The Sibford Ferris Parish Council have reviewed the revised submission by Blue Cedar homes and still strongly object to the planning application on the following basis and in addition to our previous submission:

Application No. 21/04271/F

Site Address : Land South of Faraday House Woodway Road Sibford Ferris

Plot 06
Elevations

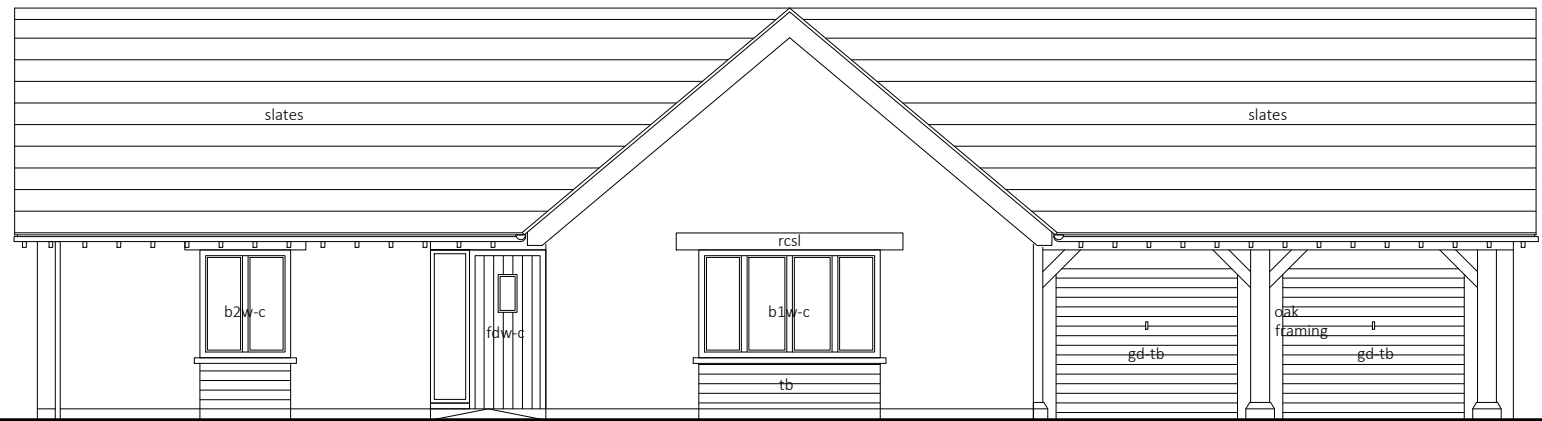
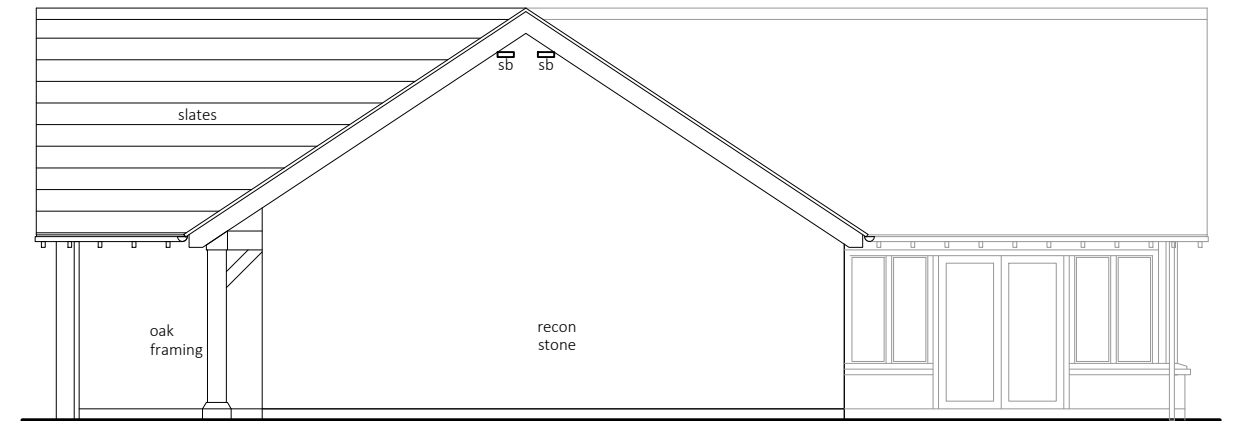
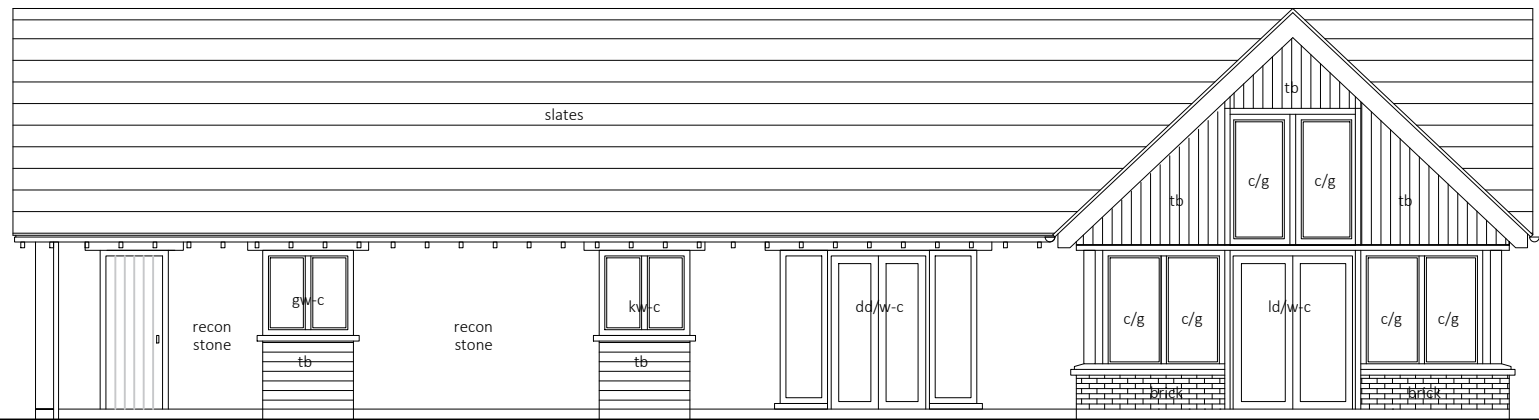
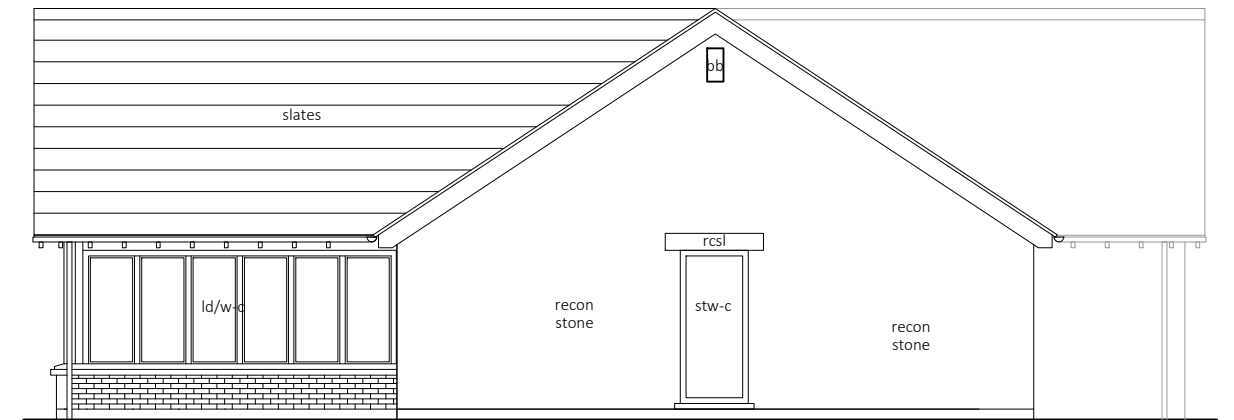
- The labeling on revised Plot 6 elevations are wrong (South elevation not labelled as such)
- Windows on the East side are invasive to privacy of the properties of High Rock, Bramley House and Butwick House.
- Faraday house will have noise and Light pollution due to vehicles turning by their property.
